Re: treeiQ Response to Submissions for SSD 7055 – F23 Administration

F23 Building

**SITE PLAN - PROPOSED  
 PUBLIC DOMAIN**

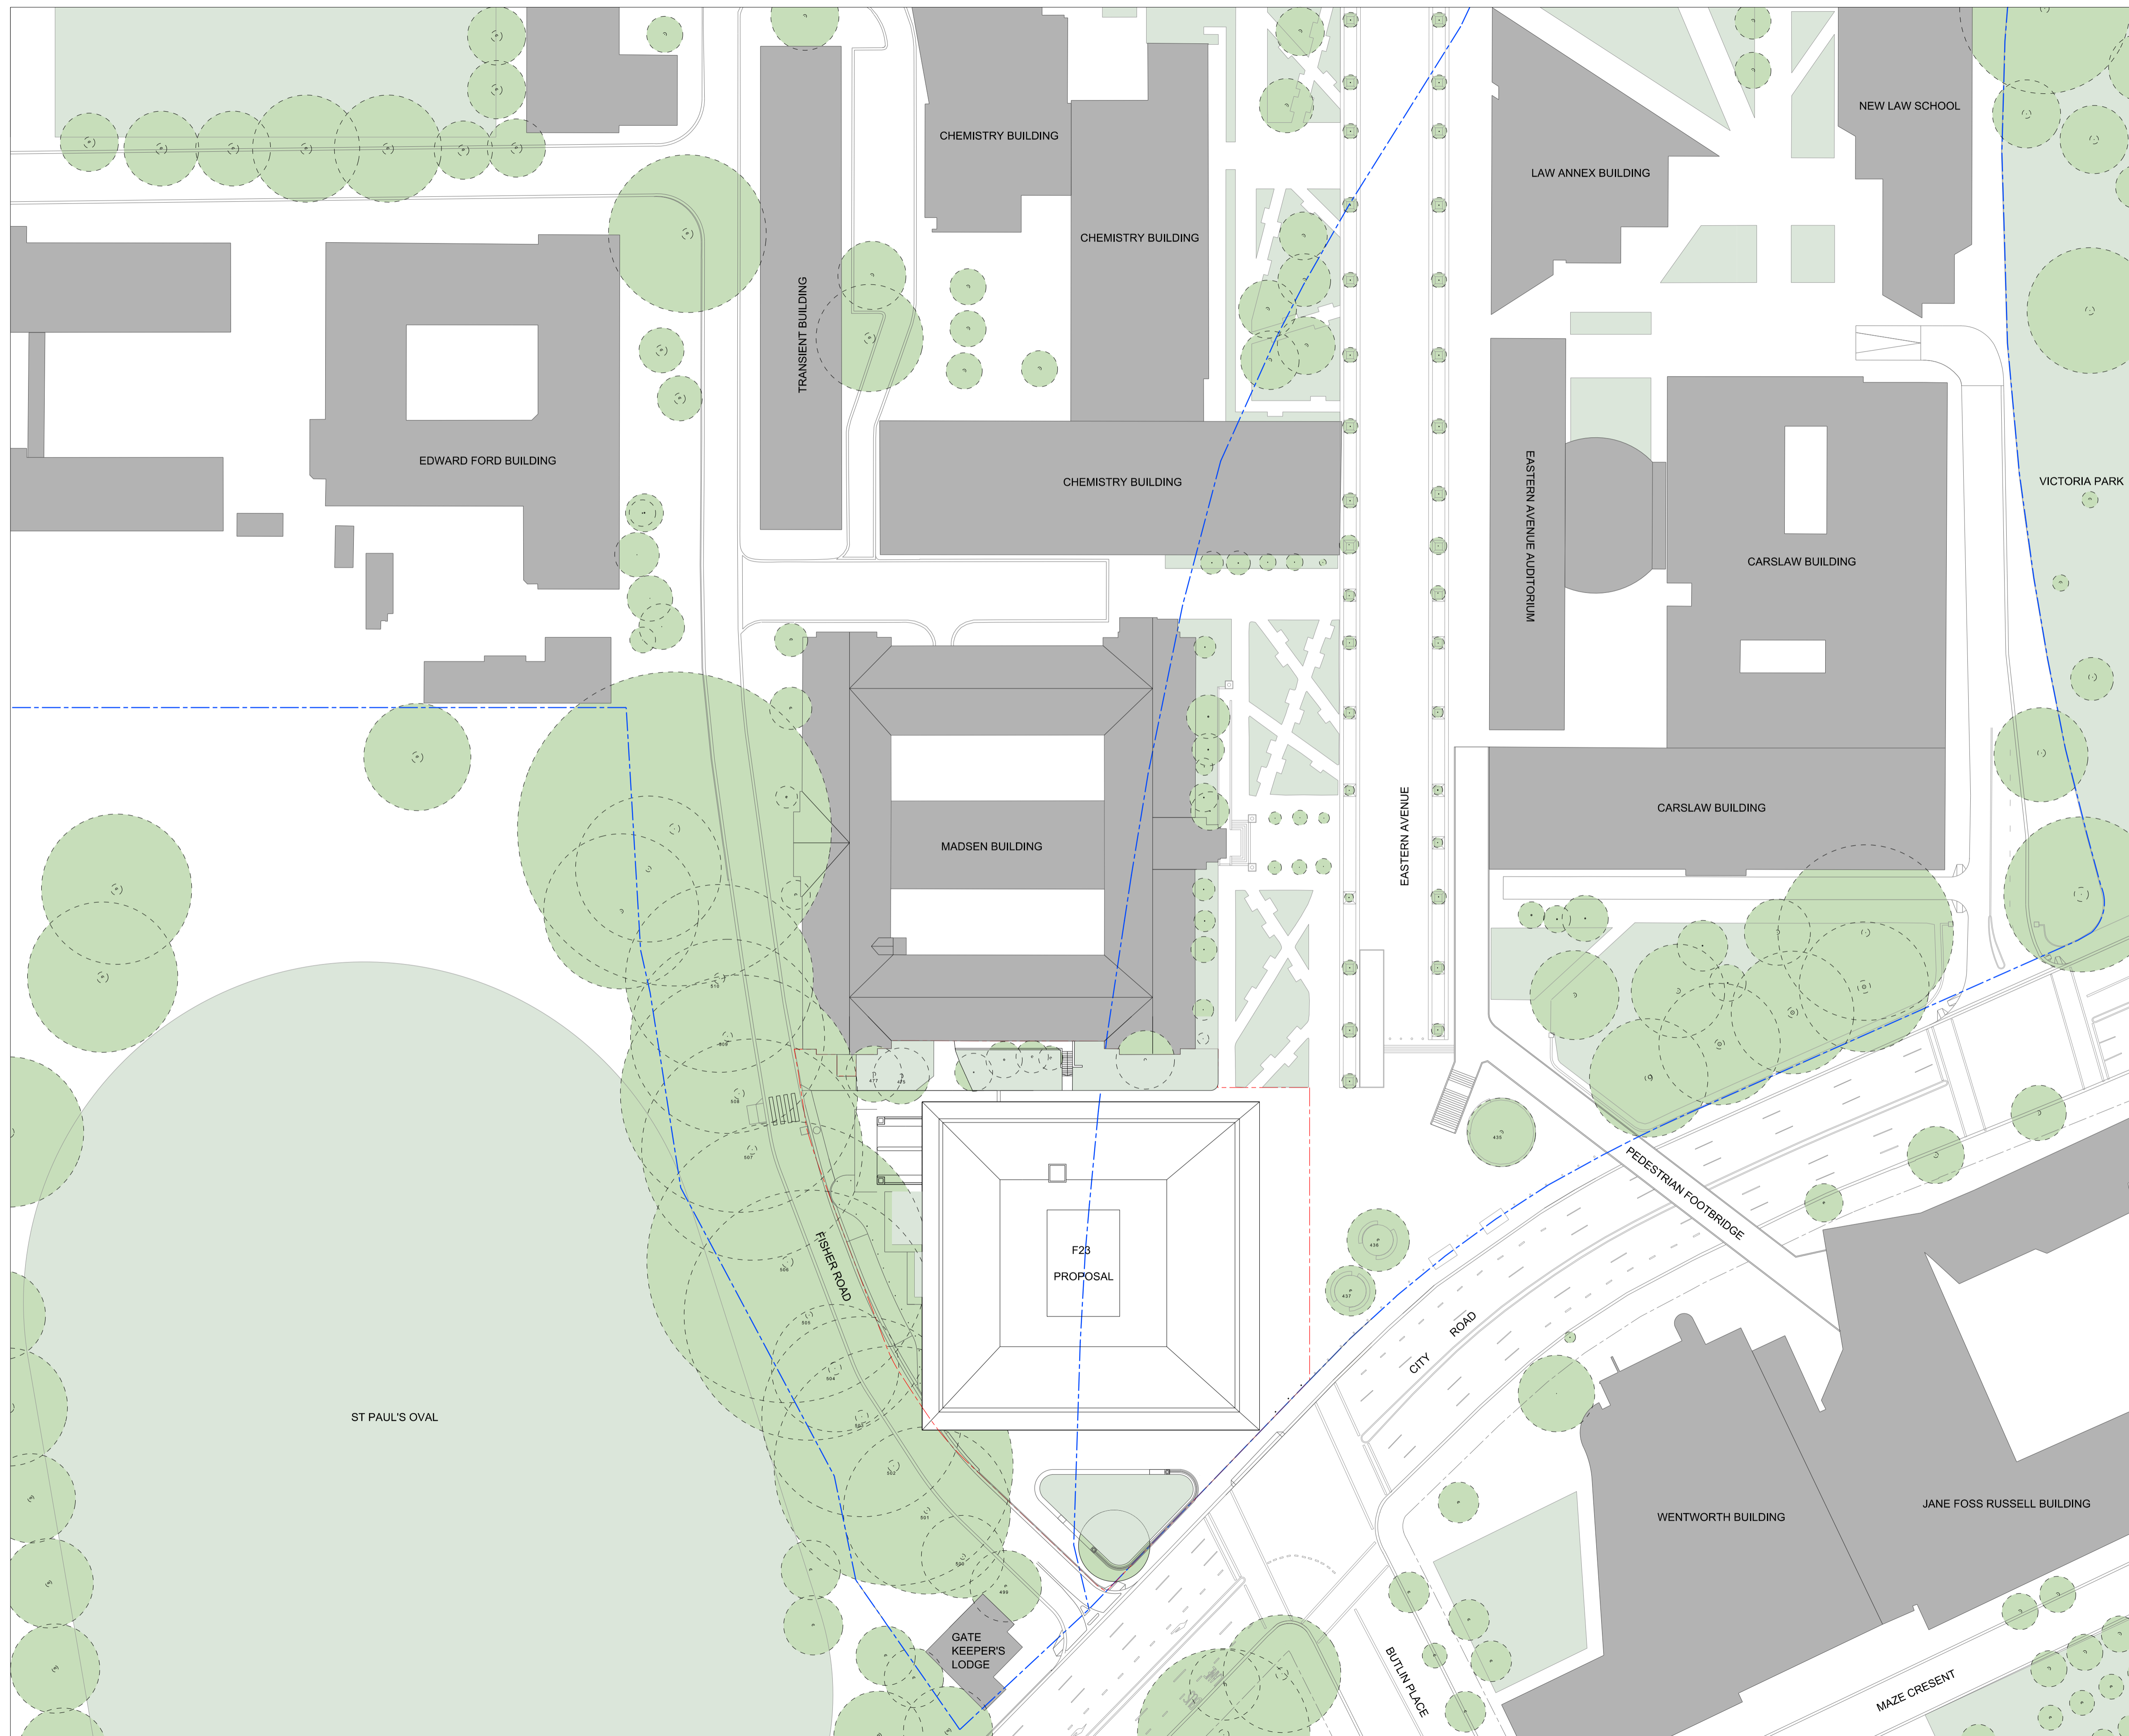
USYD Response to Department of Planning & Environment	
2 - The building design should be revised to minimise its impact on the existing heritage significant Morton Bay Fig Trees, particularly trees 501 to 503 and the subsequent requirement for any crown pruning.	The proposed F23 Building has been designed to accommodate the Science Road Figs. As indicated within the Arboricultural Impact Assessment Report Rev C (prepared by TreeiQ, dated 11.04.16) the proposed F23 Building footprint is located outside of the TPZ areas of the row of <i>Ficus microcarpa</i> var. Hilli (Trees 499-509). The south-western corner of the roof of the building projects to a small degree over the crowns of Trees 503 and 504 however it should have a negligible impact. Although no excavation is proposed within TPZ areas, in line with Arboricultural best practice, the Report recommends root pruning along the line of the proposed basement excavation closest to the trees. This will ensure roots are cleanly pruned (to promote wound compartmentalisation) prior to bulk excavation works. New kerbs and pavements in TPZ areas are to be installed at or above existing grade to minimise any potential impact to the trees. It is understood that existing kerbs directly adjacent to the trees will be left in situ. Modification of new kerbs to prevent root conflict/damage is a common practice and could be undertaken without impacting the trees.

Selective Pruning will be required to provide building and road clearances. These pruning works represent less than 5% of each individual tree's total crown volume and are not expected to reduce their Useful Life Expectancies or significantly affect their visual symmetry. Provision should be made so that additional pruning for construction access and scaffolding/hoarding is not required.
3 - The submitted Arborist report recommends replacement planting is to compensate for the proposed removal of 17 trees from the site, however, only two new trees are proposed. Justification is to be provided for the lack of proposed compensatory planting.	It is understood a new Landscape Plan is currently being prepared which includes the provision of additional replacement trees. In addition, Tree 435 is being transplanted from the front of Eastern Avenue to the front of the proposed F23 building, adjacent to City Road.
